**RE: Non Material Amendment to application Ref: LU/45/20/PL
Change of use of existing ground floor retail unit (B1 Business) to 3 No. flats (C3 Dwelling houses) Ground
Floor Unit, Saltmarsh House, Old Market Lane, Littlehampton. BN17 5FB.**

The amended drawing showing the non-material amendments is PDP Architecture LLP drawing 28132-PD110 Proposed Floor Plans and Proposed Elevations.

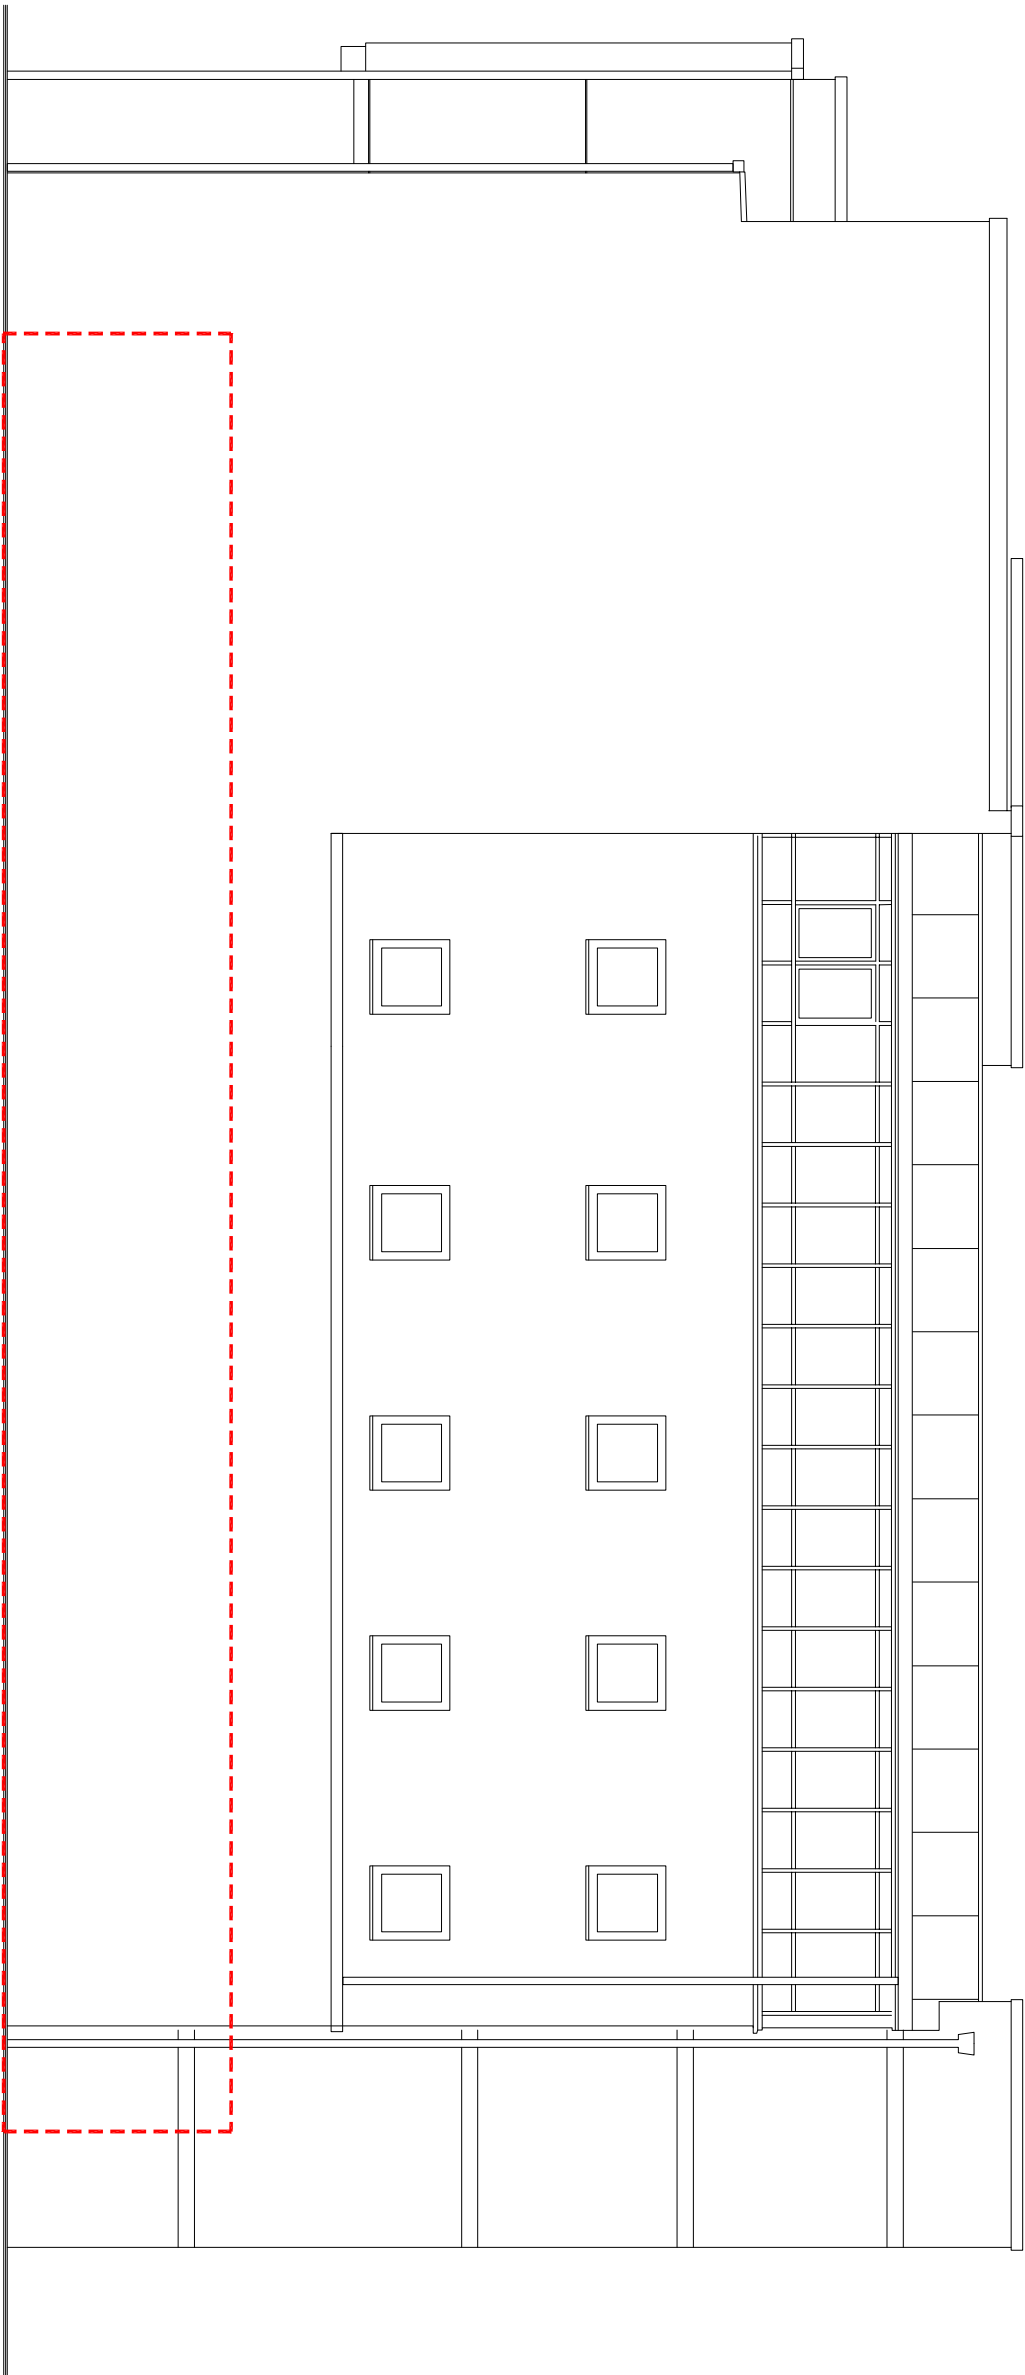
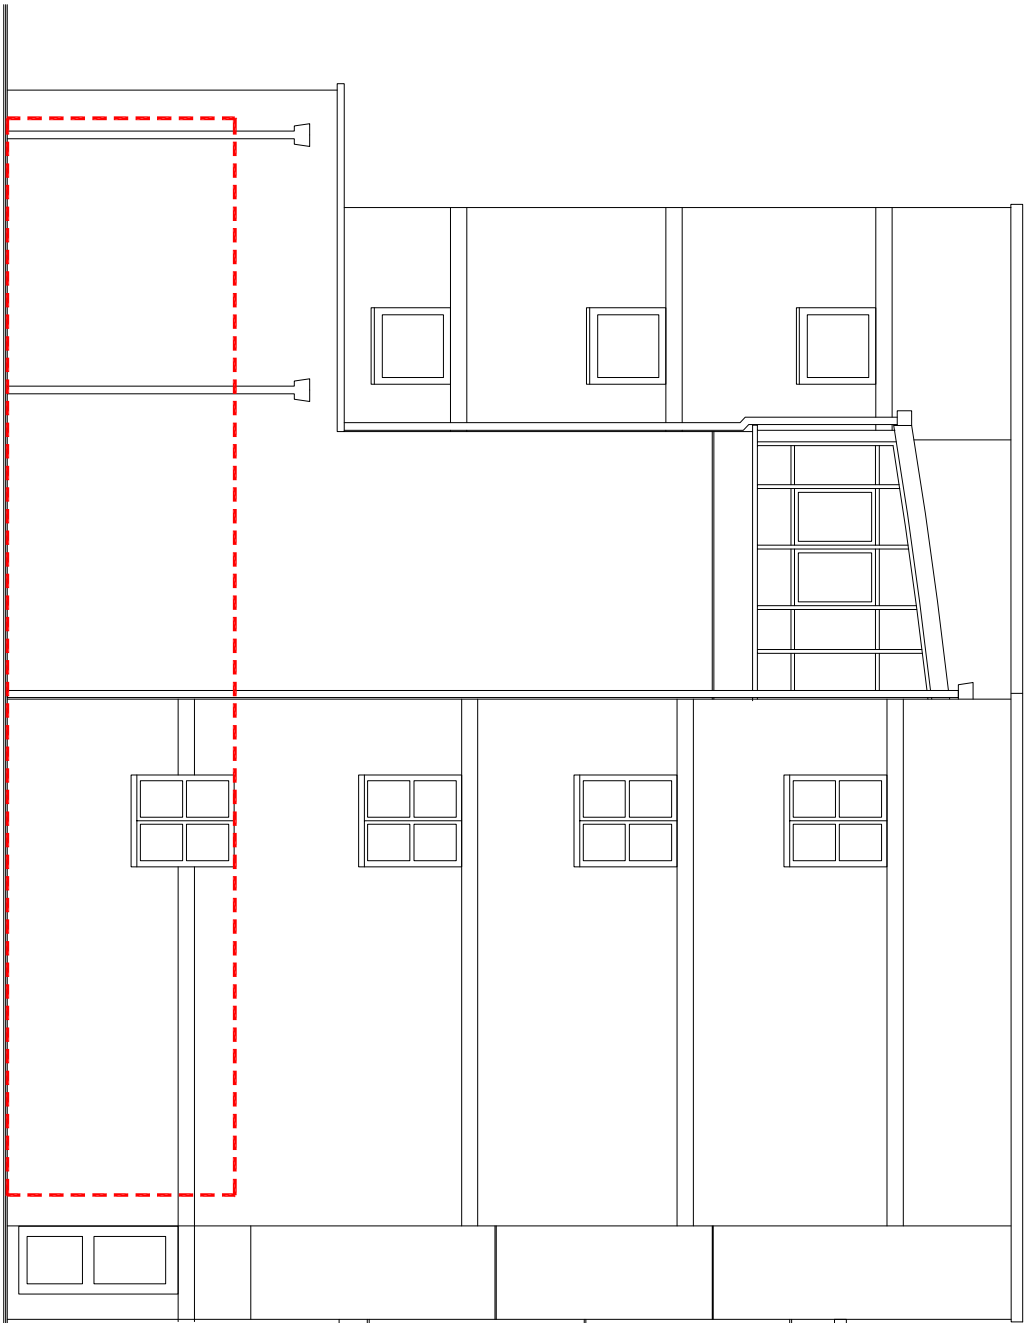
The approved plans show fenestration configuration on an existing building which did not take into account the existing services which are located on the eastern elevation. As such a non-material amendment is sought to relocate the fenestration so as not to affect the existing services (gas meter boxes/ gas pipes & electric meter boxes) and therefore not disrupt existing residents in the dwellings on the upper floors to the existing building.

Likewise the north elevation fenestration showed an inset external amenity area on the back edge of footpath which would not create a desirable space for the dwelling resident and due to the beam and block floor to the existing ground floor structure would result in cold bridging issues to create such a recess which would not be practical to build.
